Fire Marshal Division

**Re: Fairview Apartments and Fire Alarm Plans
Gallery Drive
Spring Lake, NC 28390**

Application Number BCOM1907-0005

1
FA1 FIRE ALARM PLAN-1ST FLOOR
 3/16"=1'-0"

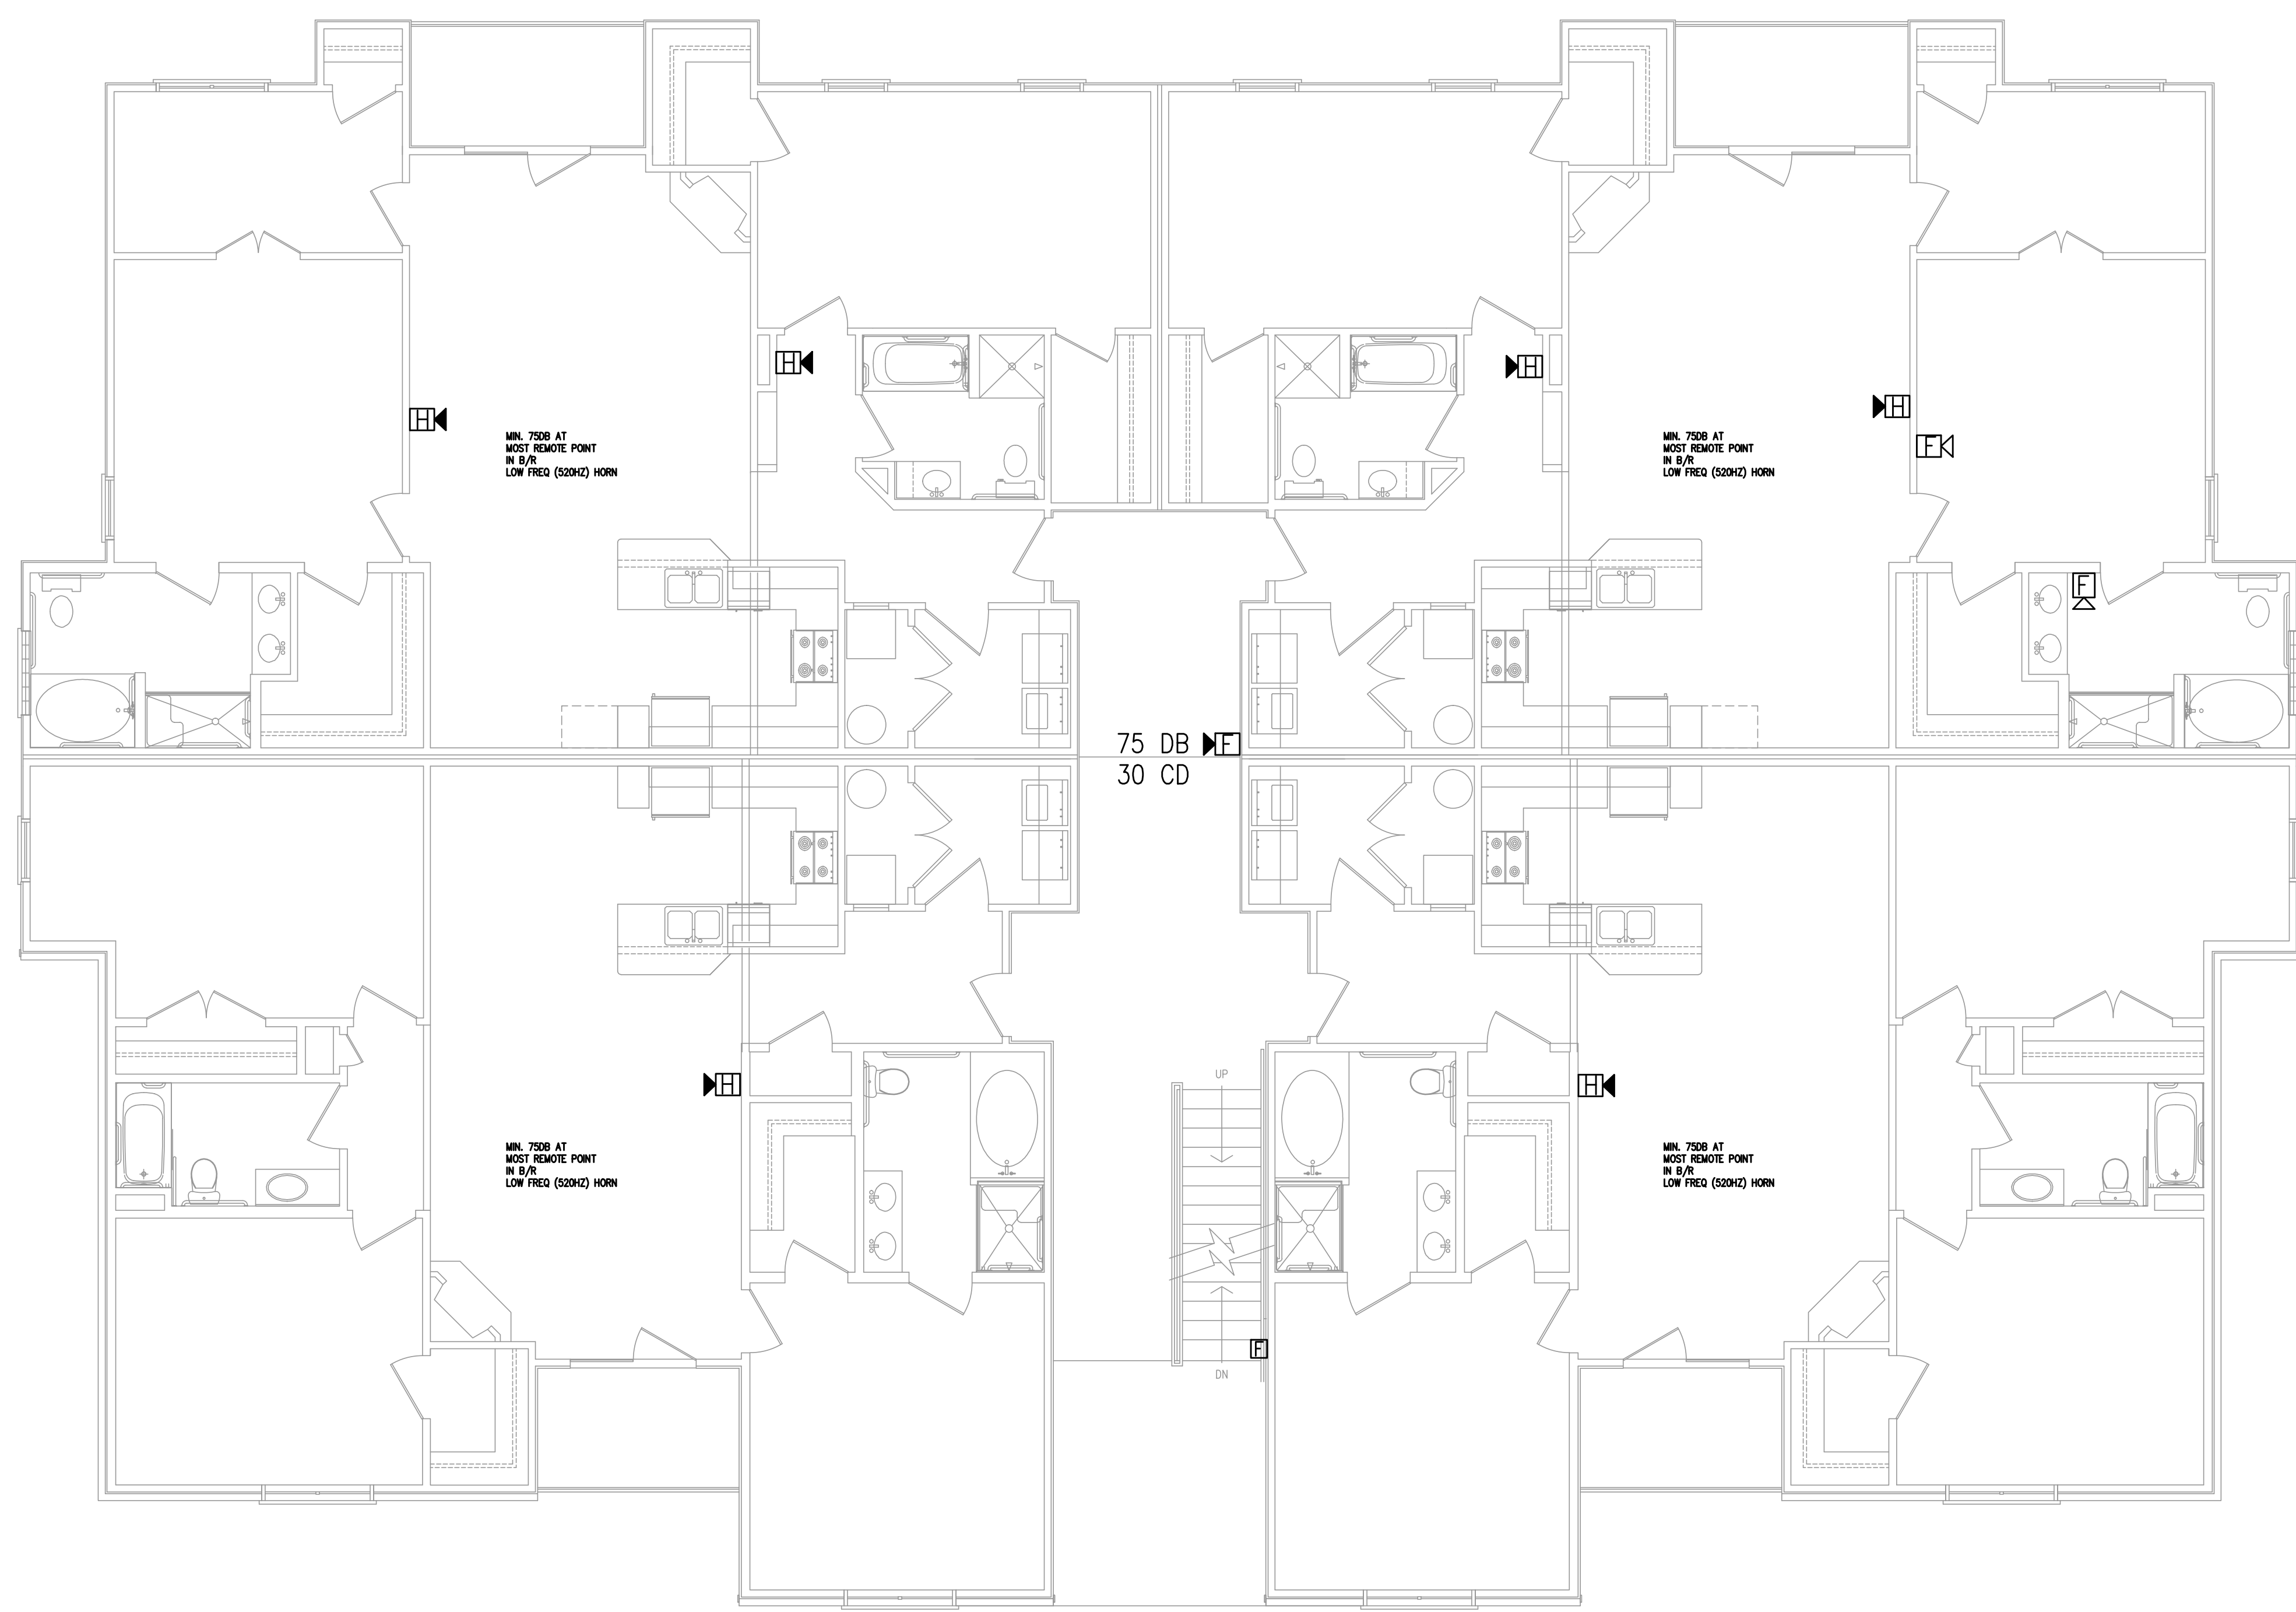
- **Fire Extinguishers**
 - The fire extinguishers provided shall have a minimum rating of 2A 5B:C and shall not be installed higher than 5 feet above the finished floor

- Fire extinguishers located in the common areas of the apartment buildings shall be located in the common stairwells and mounted in an approved weather proof container.

- A floor plan which indicates the use of all rooms.
 - Locations of alarm-initiating and notification appliances.
 - Alarm control and trouble signaling equipment.

- Battery calculations.
- Conductor type and sizes.
- Voltage drop calculations.
- Manufacturers, model numbers and listing information for equipment, devices and materials.
- Details of ceiling height and construction.
- The interface of fire safety control functions.
- The current plans include the basic device layout, but does not include the other required information.
- All duct detectors shall be interconnected with the fire alarm system.
